Recommendation Report for Planning Permission

REF NO: FP/185/19/PL

LOCATION: Mermaid and Playbox
Sea Road
Felpham
PO22 7AW

PROPOSAL: Detached dwelling - Resubmission of FP/201/18/PL

WEST ELEVATION

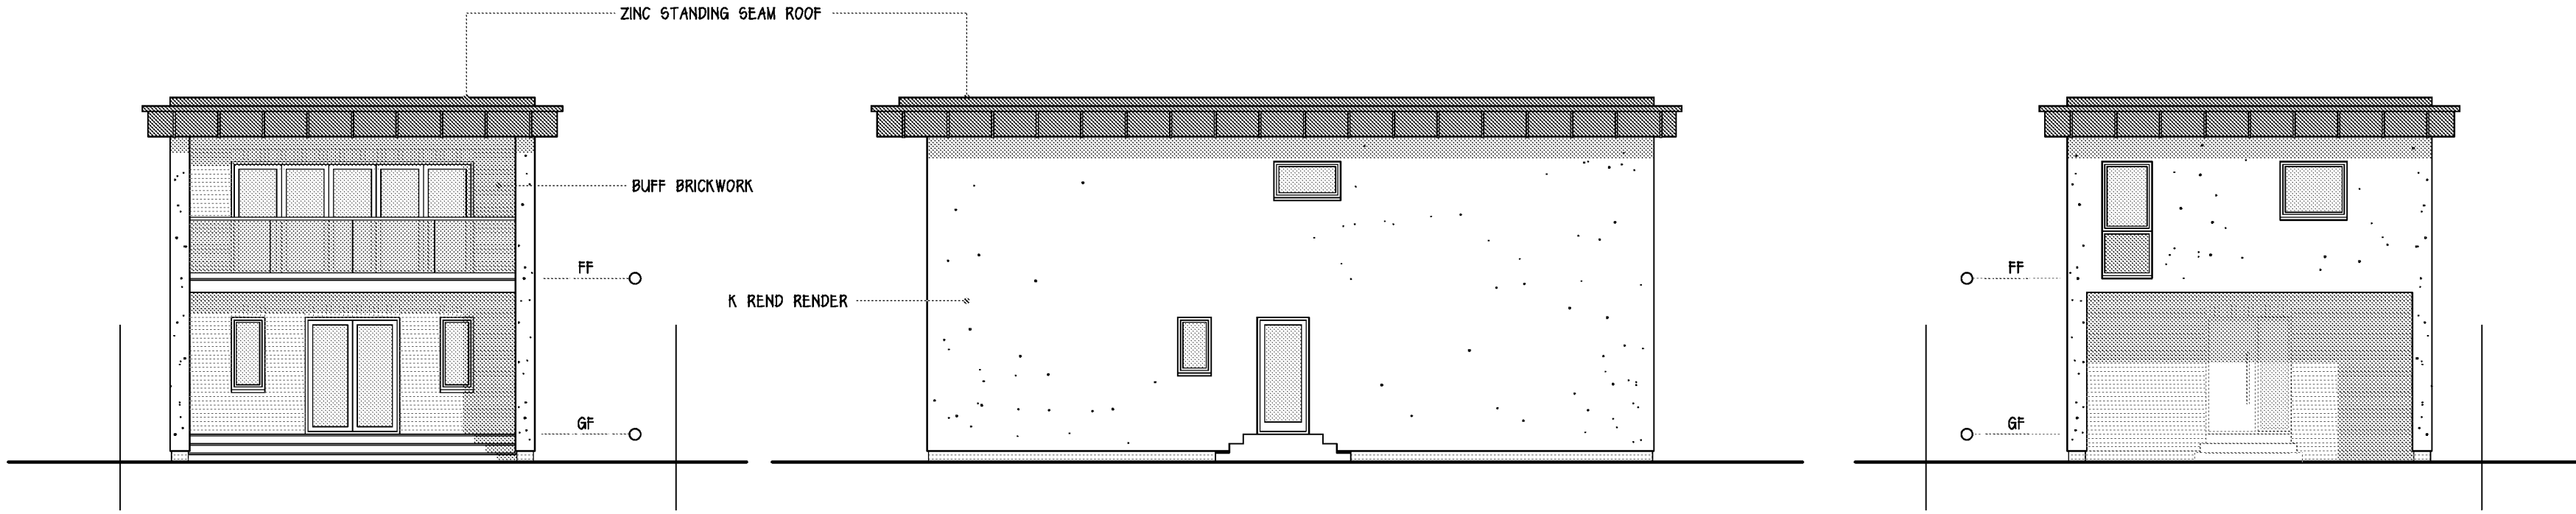
- 9) Proposed property is plain ugly with a featureless 2 storey wall facing west
- 10) Plans show accommodation on the ground floor in a flood risk area that has been rejected for other plans in the area

The proposed building would comprise 2 storeys and would feature a single window at first floor level which serves the proposed bathroom. This first floor window could be finished in obscure glazing which could be secured by way of condition. However, the building would be situated in close proximity to the western elevation of Shingle End. On the date of my site visit I noted that the western elevation provided a number of windows which appeared to serve habitable accommodation.

Owing to the proximity of the proposed development to Shingle End to the east, combined with the location of windows along the western elevation of Shingle End, would result in a form of development that would have an unacceptable perception of overmassing and overbearing impact upon the current and future occupants of Shingle End. This would result in demonstrable unacceptable impacts upon the living conditions of the occupants.

FIRST FLOOR PLAN

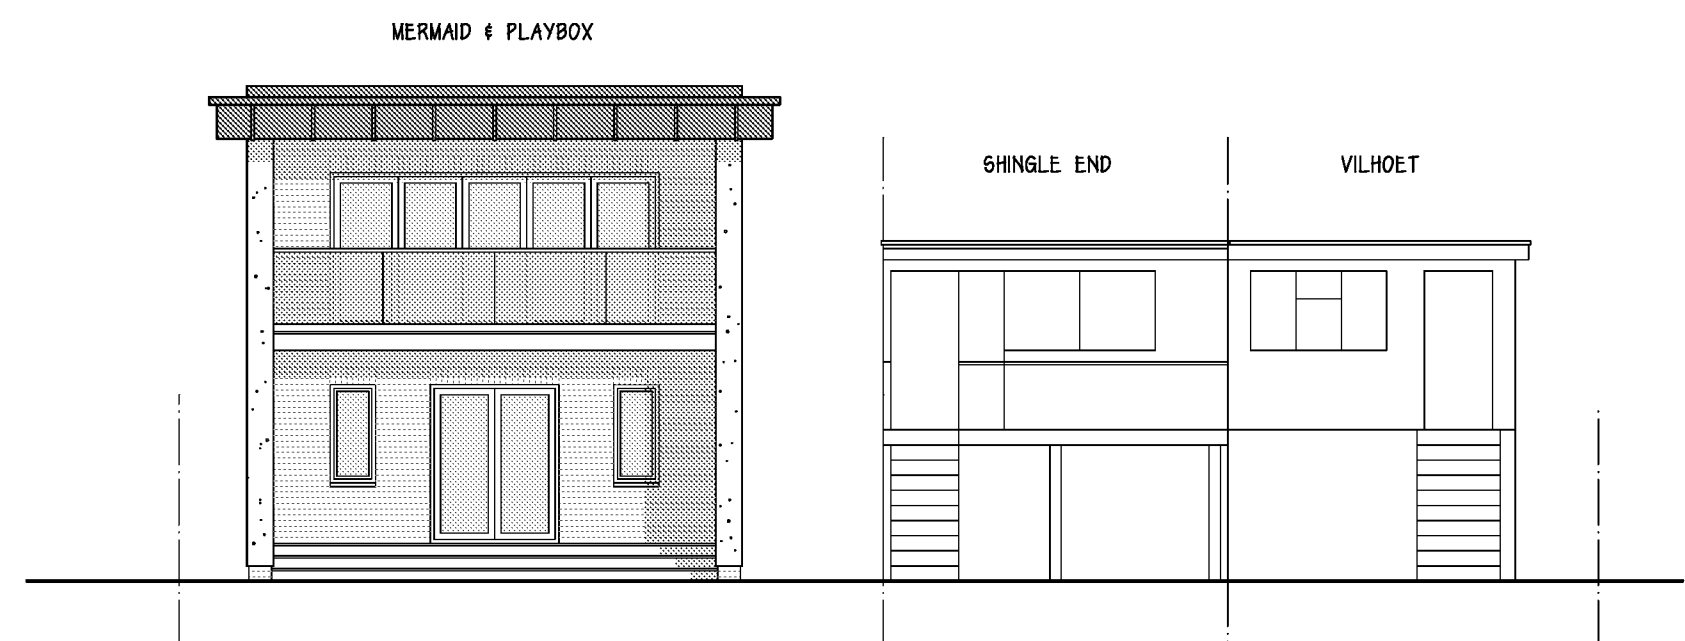
The application does not demonstrate that occupants can remain safe for the lifetime of the development, we would recommend that sleeping accommodation should not be placed on the ground floor in this location.

Finished floor levels shall be set no lower than 4.05 m above Ordnance Datum (AOD). No bedrooms shall be located on the ground floor. These mitigation measures shall be fully implemented prior to occupation and subsequently in accordance with the scheme's timing/phasing arrangements. The measures detailed above shall be retained and maintained thereafter throughout the lifetime of the development.

BLOCK PLAN

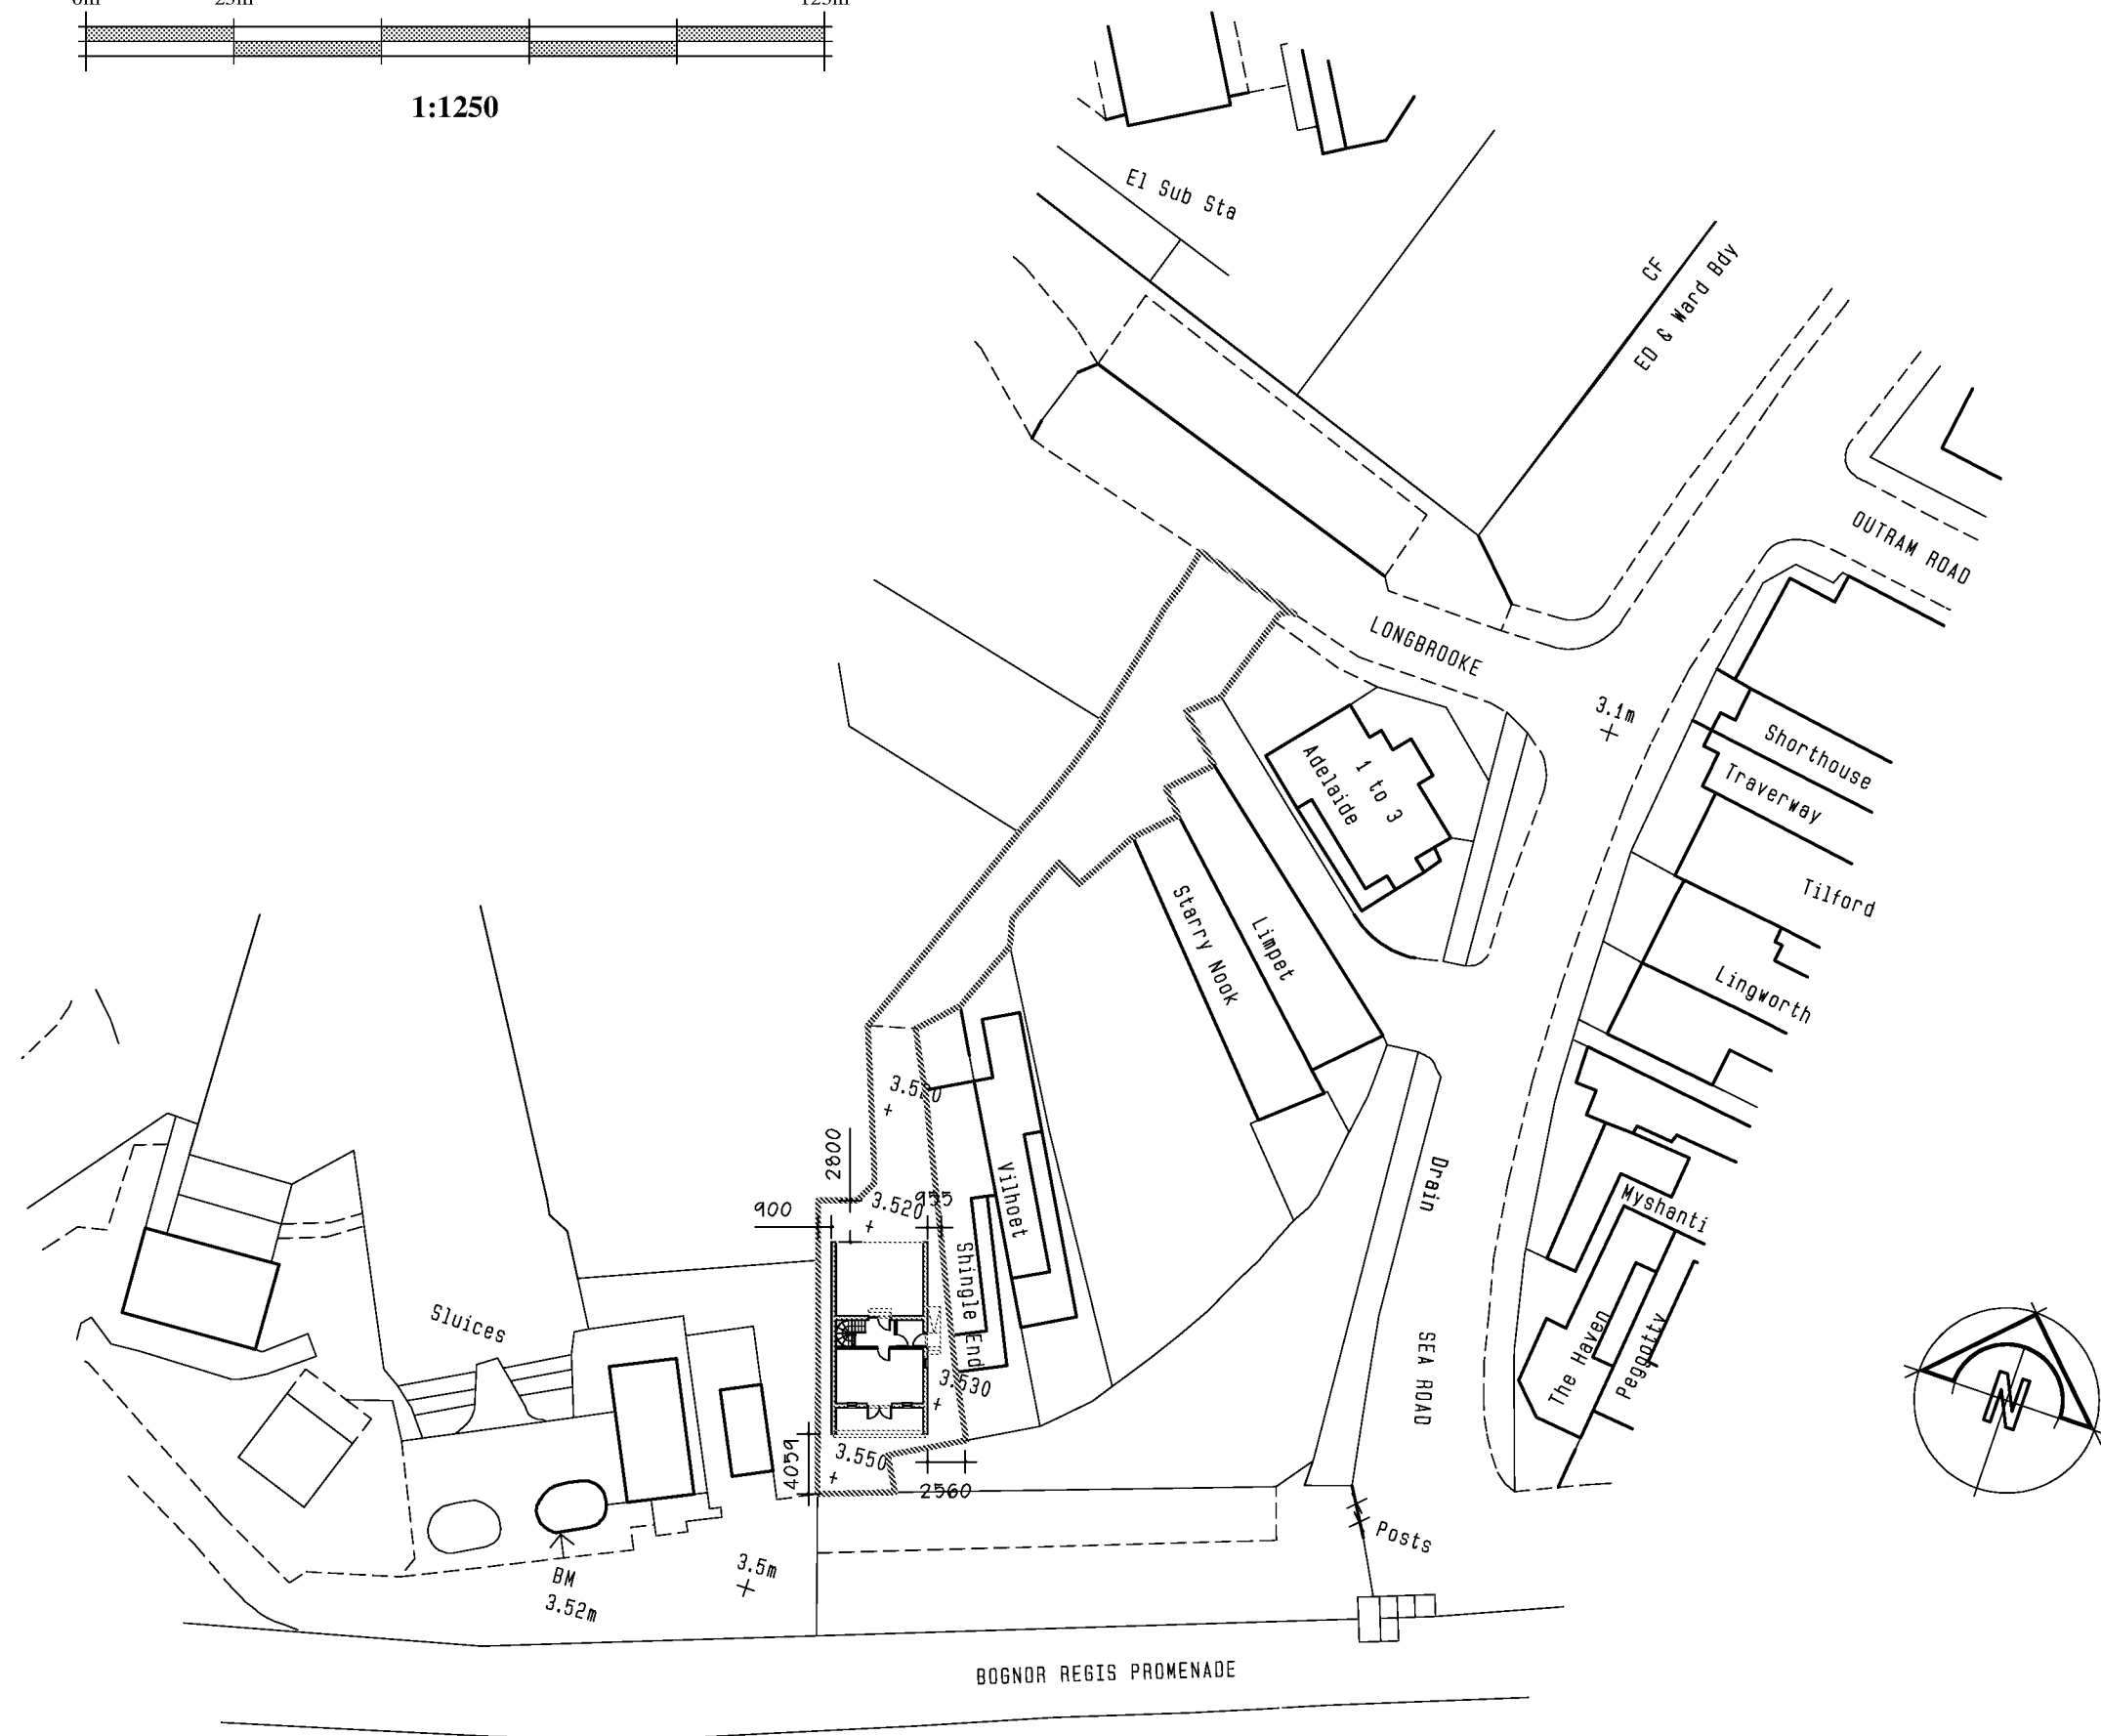
The application form does not specify details of parking on site. The proposed plans indicate that a covered parking and turning area will be provided on site, providing parking for two vehicles. These spaces appear to meet the minimum specifications as set out in Manual for Streets (MfS). The WSCC car parking demand calculator anticipates that a minimum of three parking spaces would be required for a dwelling of this size and location. Whilst there would be sufficient space on site for a third vehicle to park, this would remove the ability for vehicles to turn on site. However, the LHA would not anticipate any highway safety concerns with the lack of a turn on site, as it is expected that vehicles will enter onto the publicly maintained highway in a forward gear.

The application site falls within Parking Zone 4 under West Sussex County Council and Arun District Council guidance. WSCC provision requires 1.7 spaces in Zone 4 for a 2 bedroom dwelling and ADC guidance requires 1 space for a 2 bedroom dwelling. The development would provide 2 no. spaces in total; one comprising an open air space and another within the undercroft parking area. West Sussex County Council did not provide any objection to the size of the spaces or level of provision.

The applicant has not shown any cycle parking provision which would require 1 space per 2 bedroom dwelling under WSCC and ADC guidance. However, should the development be found to be acceptable then cycle provision could be secured by way of subsequent discharge of condition process.
